Our Ref: 7476/LRW/kc

Date 13th February 2024

Re: **Land rear of Chicane and Quintons, Ockham Road North, East Horsley, KT24 6PU** – Condition 8 Ref LLFA-GU-22-0445 Rev B

Further to the recent holding objection relating to the clearance of Condition 8 of the reserved matters planning approval for this site we enclose our response to queries along with supporting documentation.

DRAWING
Detention Basin
Details

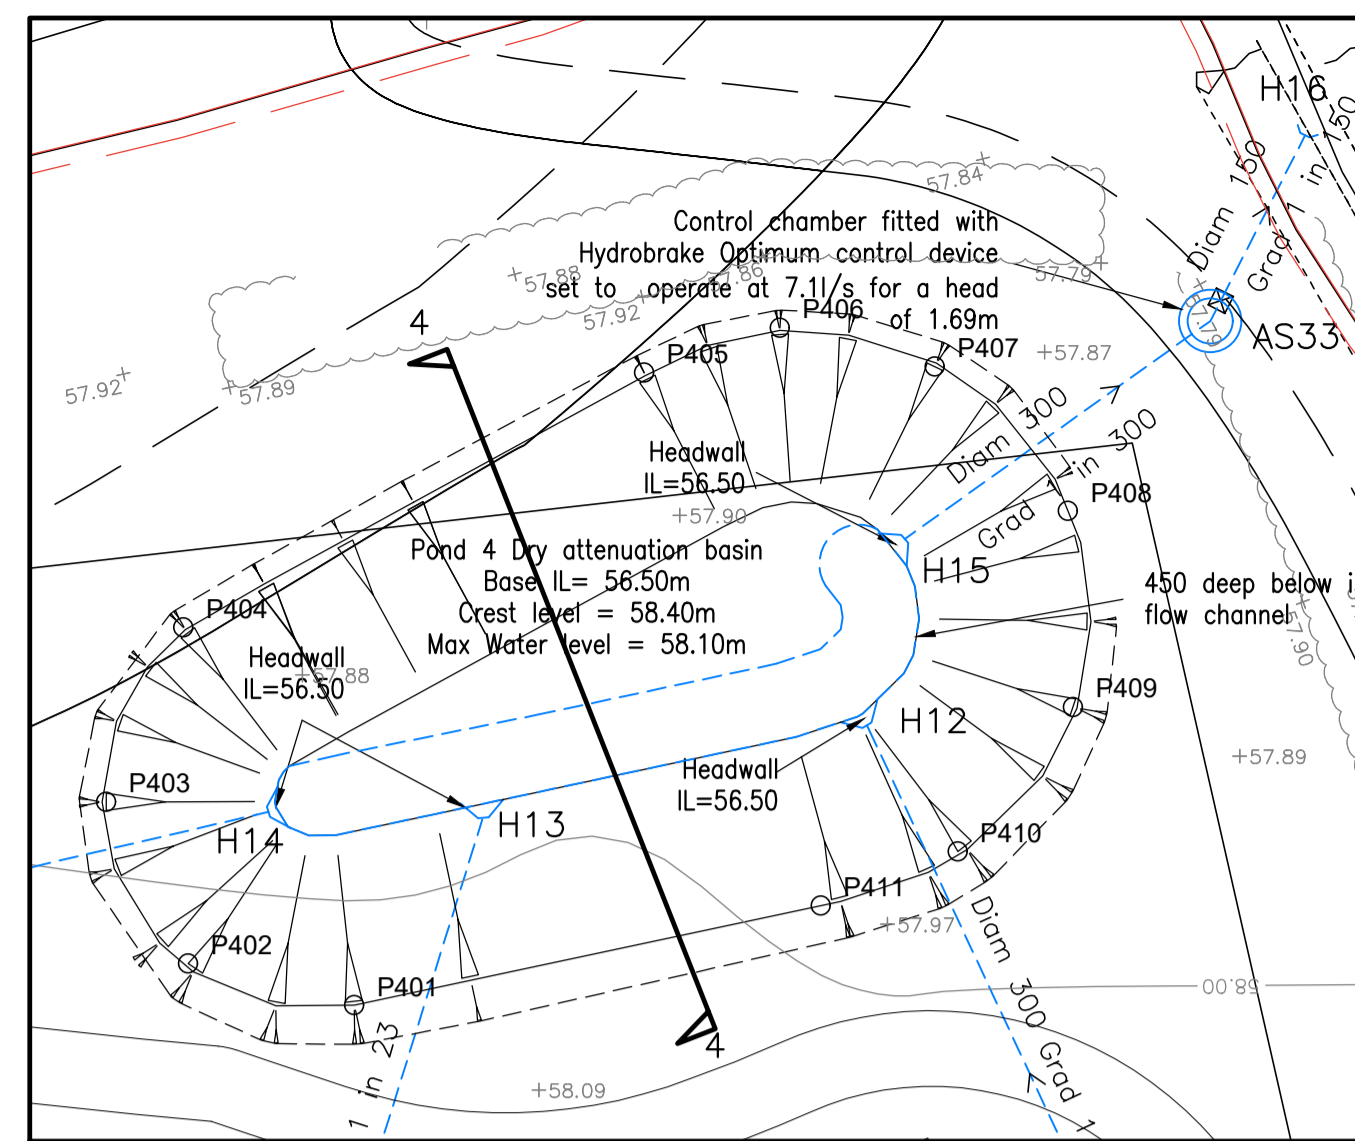
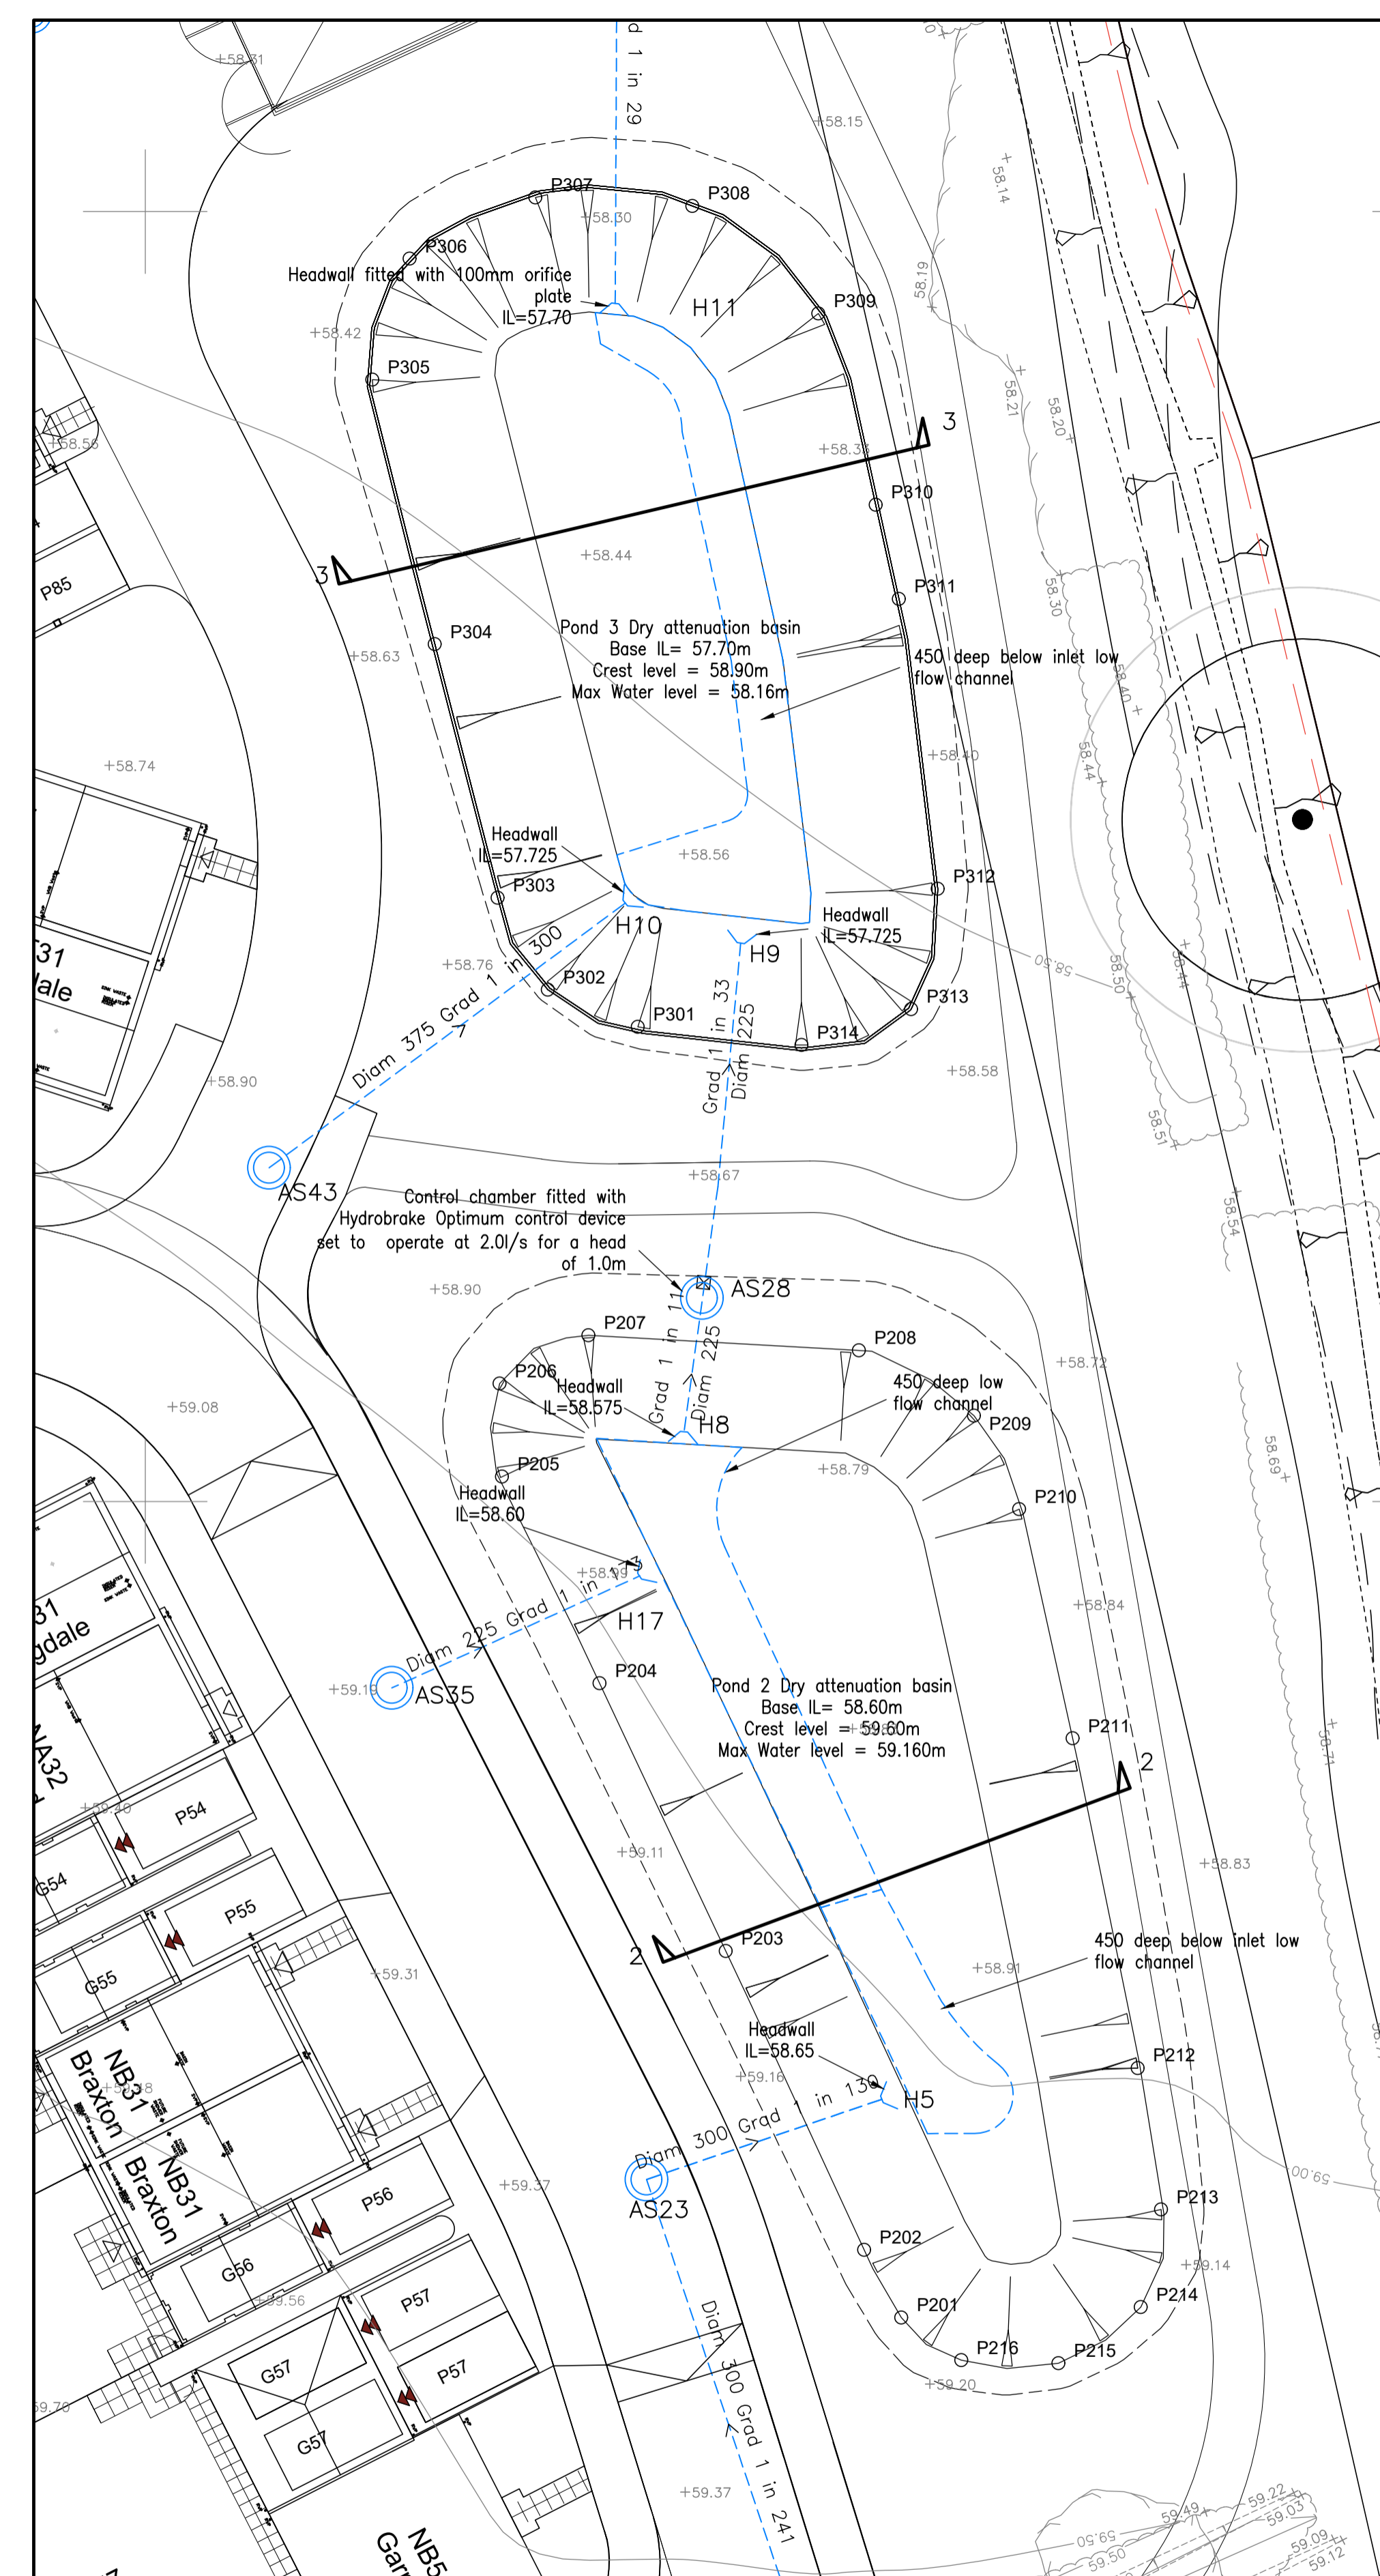
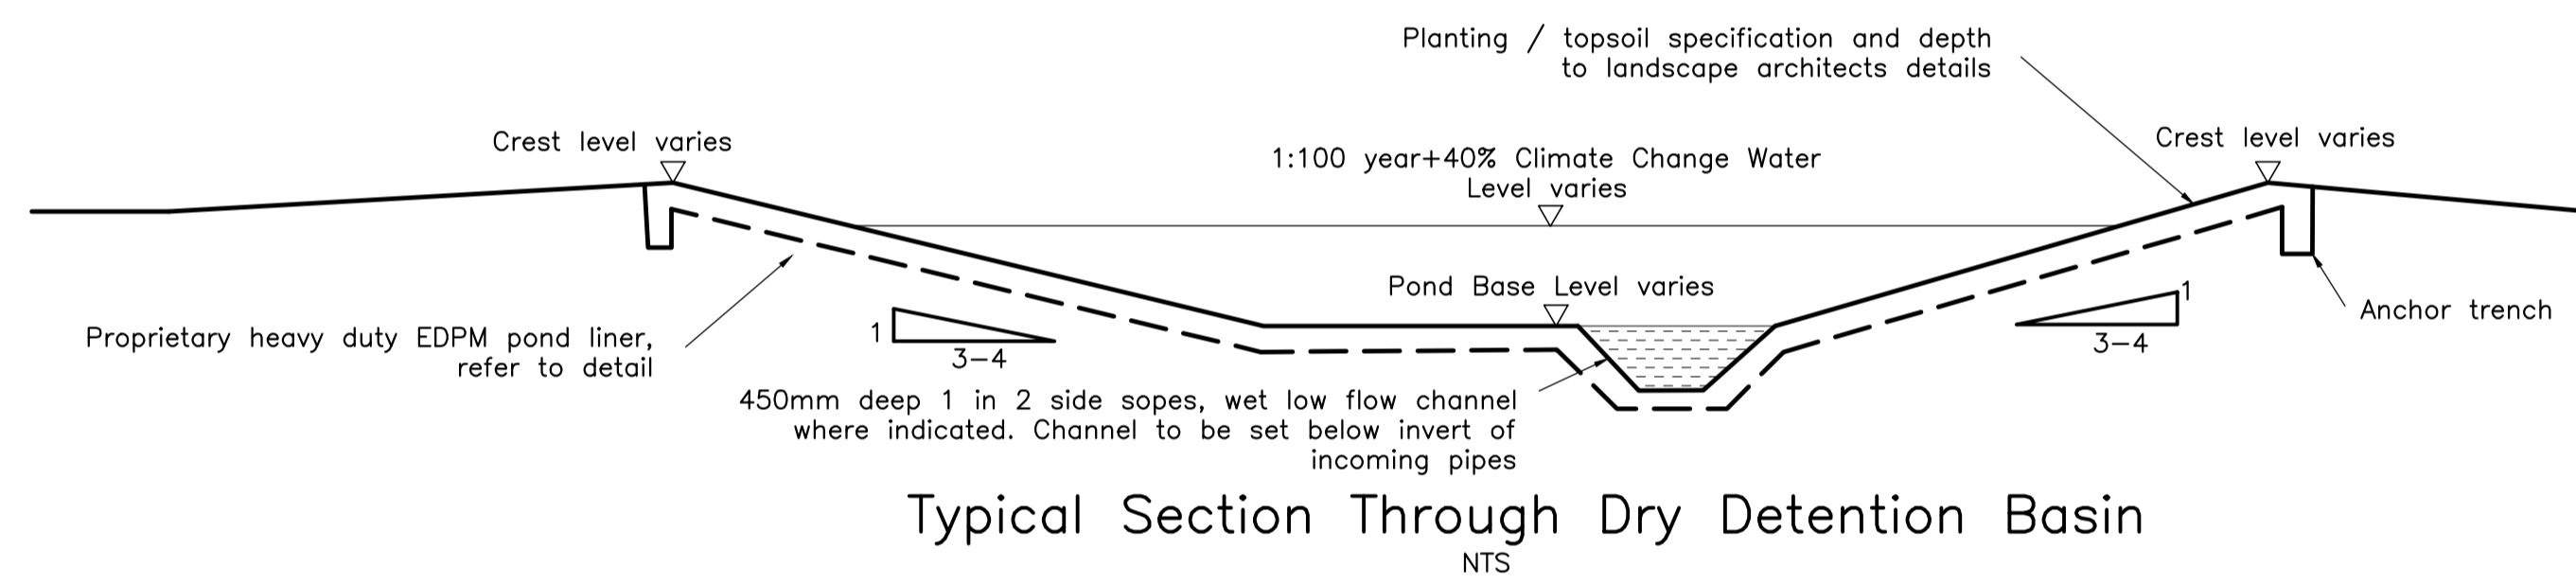
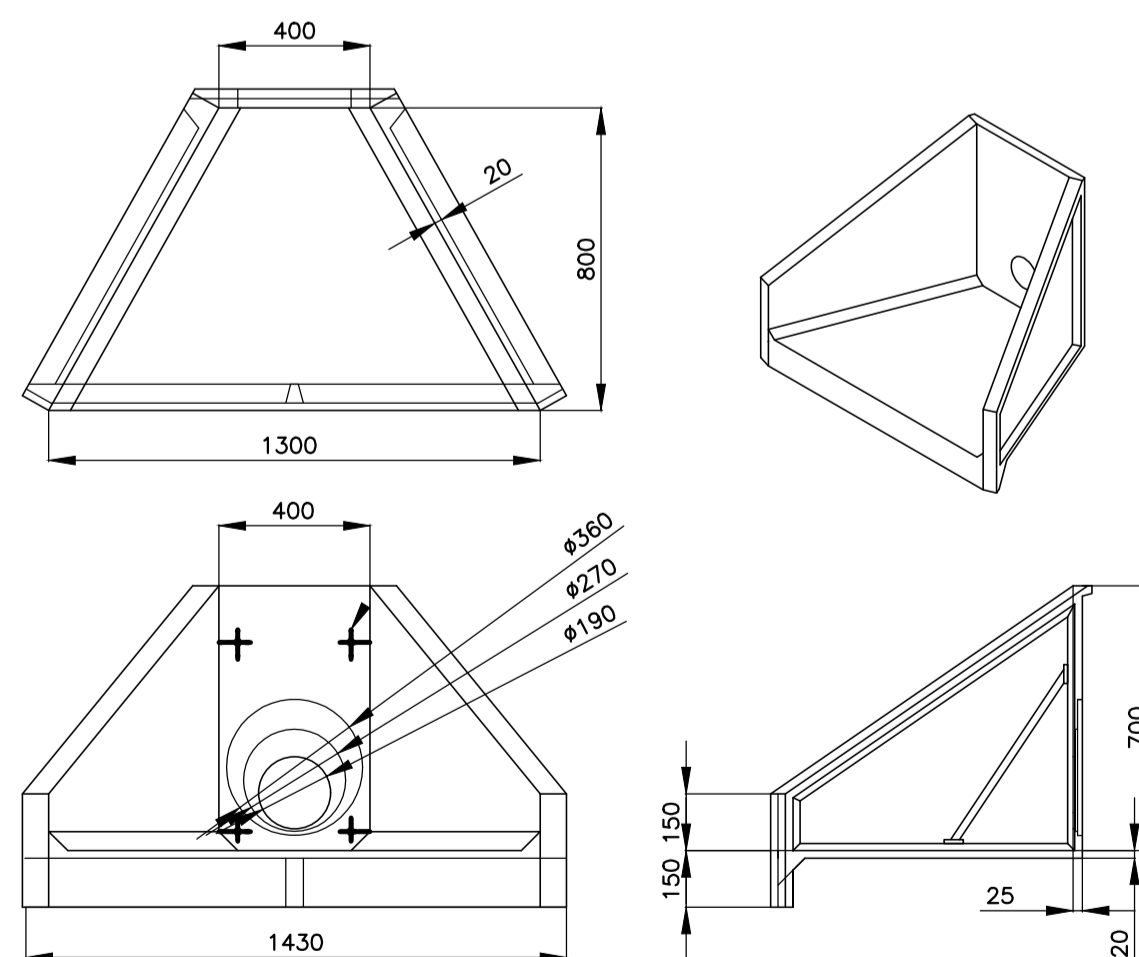
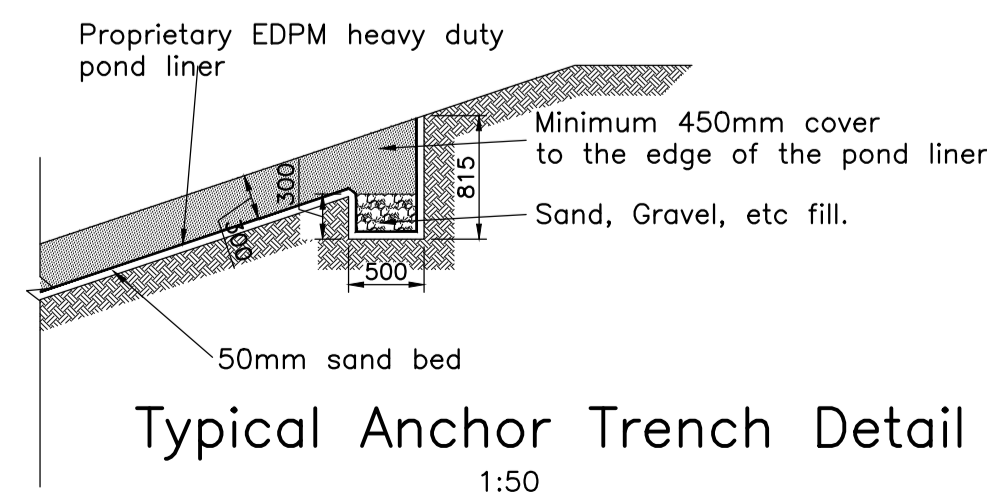
- i. Basin sections. No levels or development layout shown on drawing for context and to enable cross check with calculations. – Section lines not indicated.

- v. Outlet headwalls (i.e. those into the flow control chambers) should have angled trash screens to protect the flow control and for ease of maintenance.

i. The development layout had been removed from the drawing for clarity. Context in regard to development layout and levels is provided on the engineering plans. However as requested the development layout has been added back to the plan along with the section markers.

v. All basin outlet headwalls have angled trash screens as noted on the section on drawing C7476/CE13E.
